Objection to Planning Application AW/197/20/PL

Planning Application AW/197/20/PL The former Ship Inn Variation of Conditions applied to previous Planning decision AW/211/14/PL

Articulated Deliveries Vehicle
with Refuse Vehciles Passing
scale 1:500 @ A1

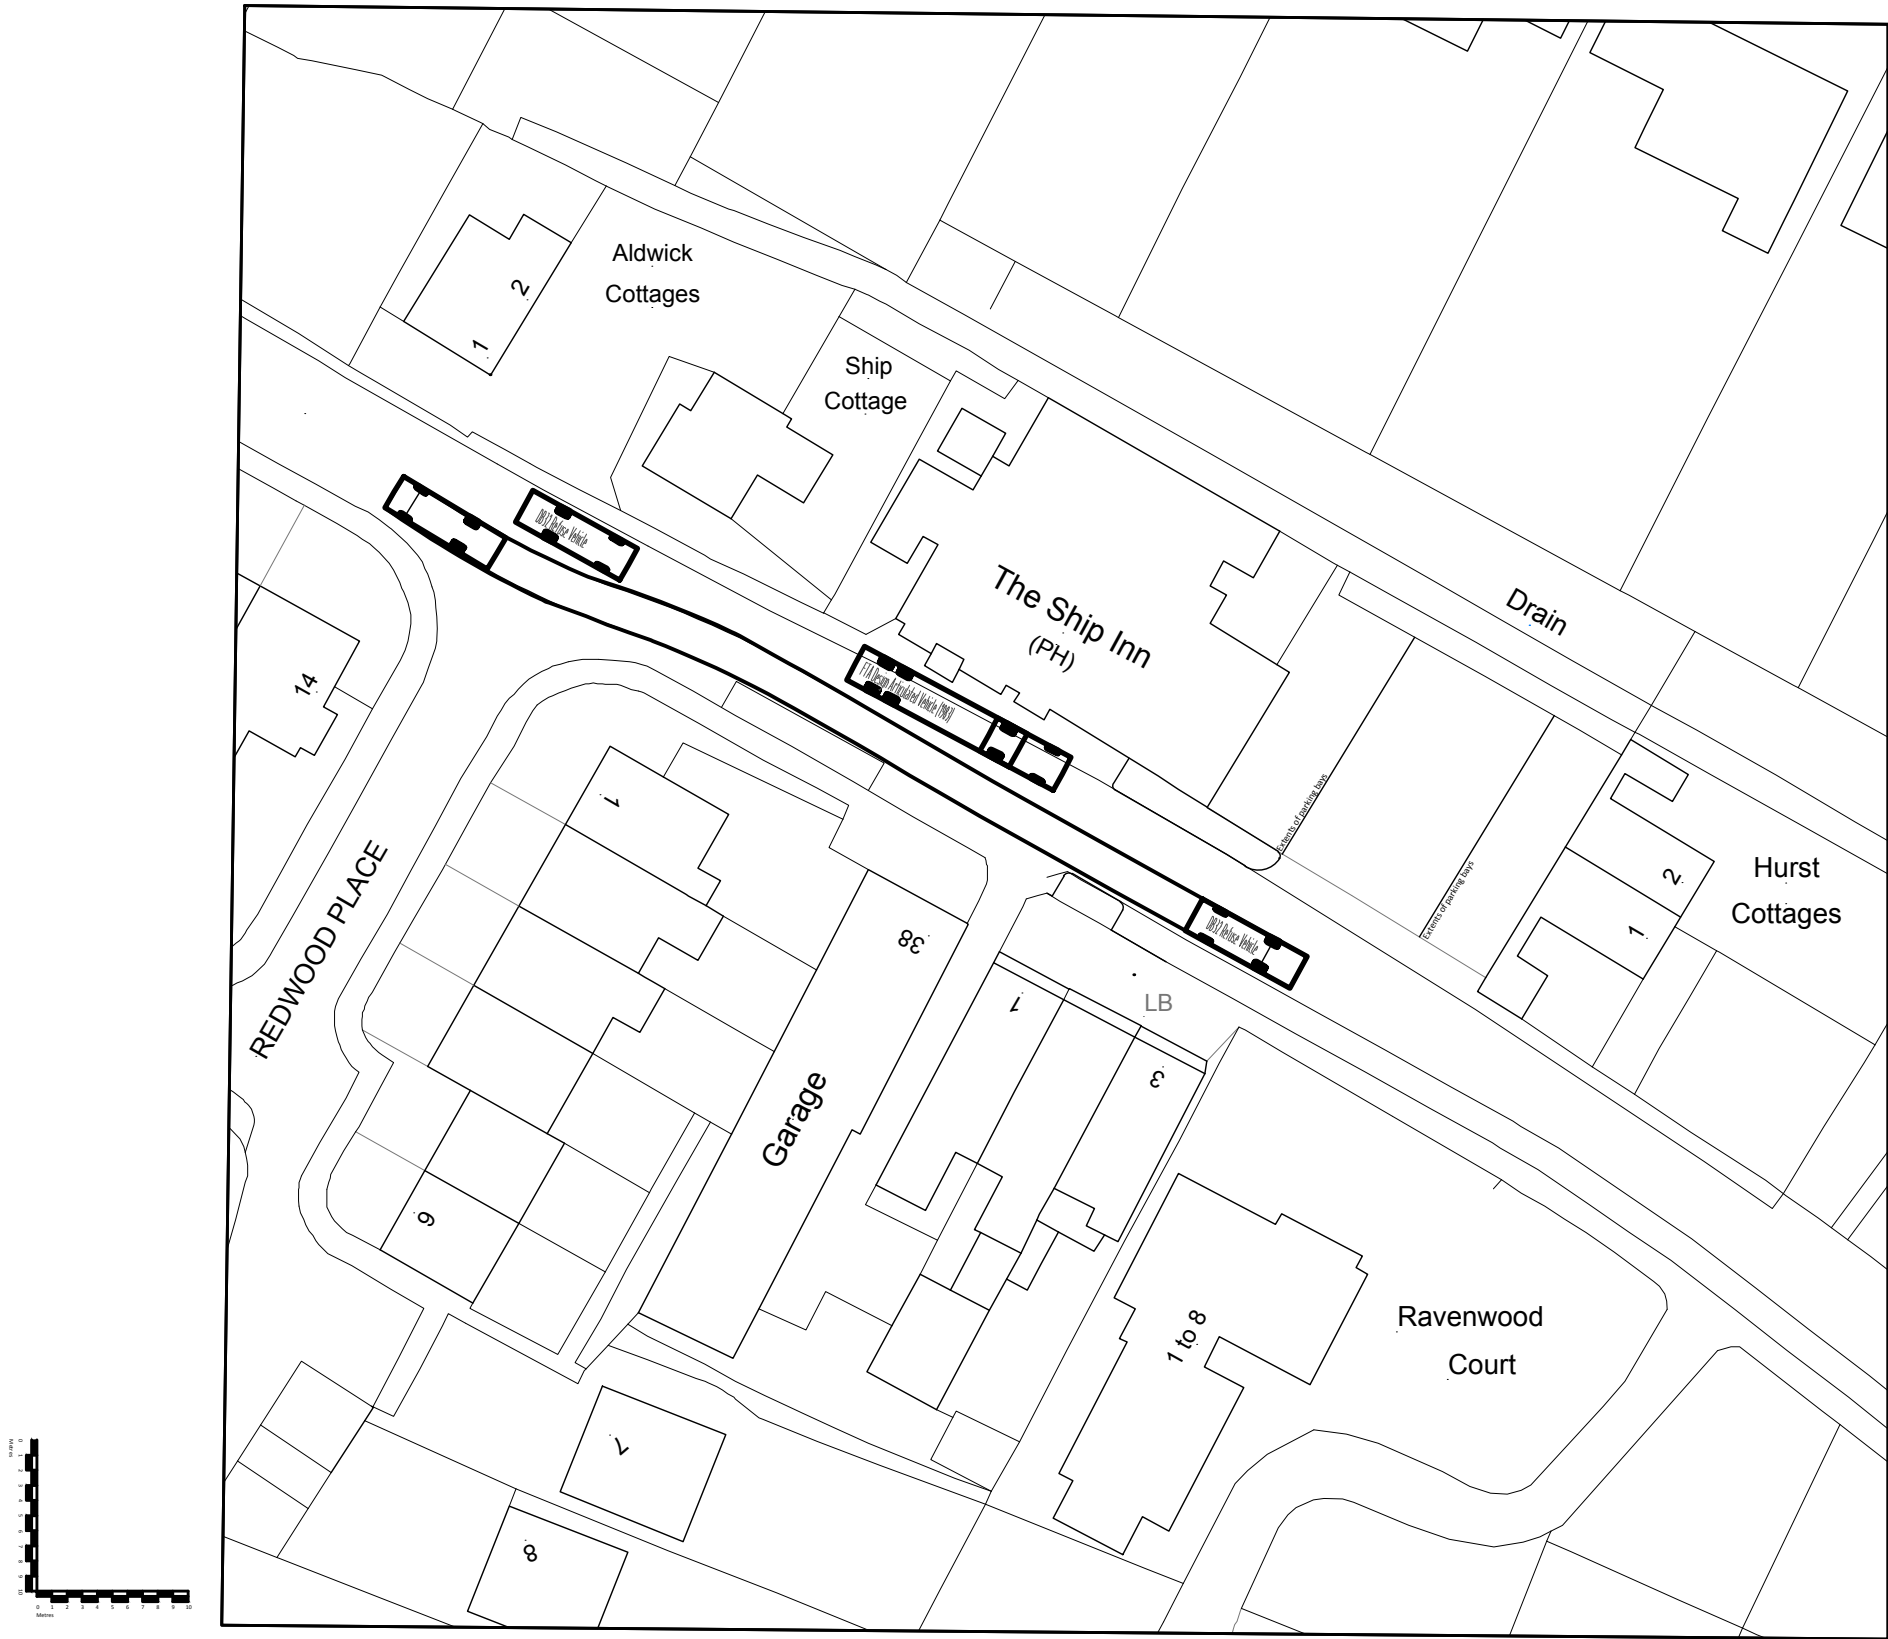
With traffic passing as close as given in the drawing B200038 B203 and B204 submitted, the unloading area will not be clear of other traffic.
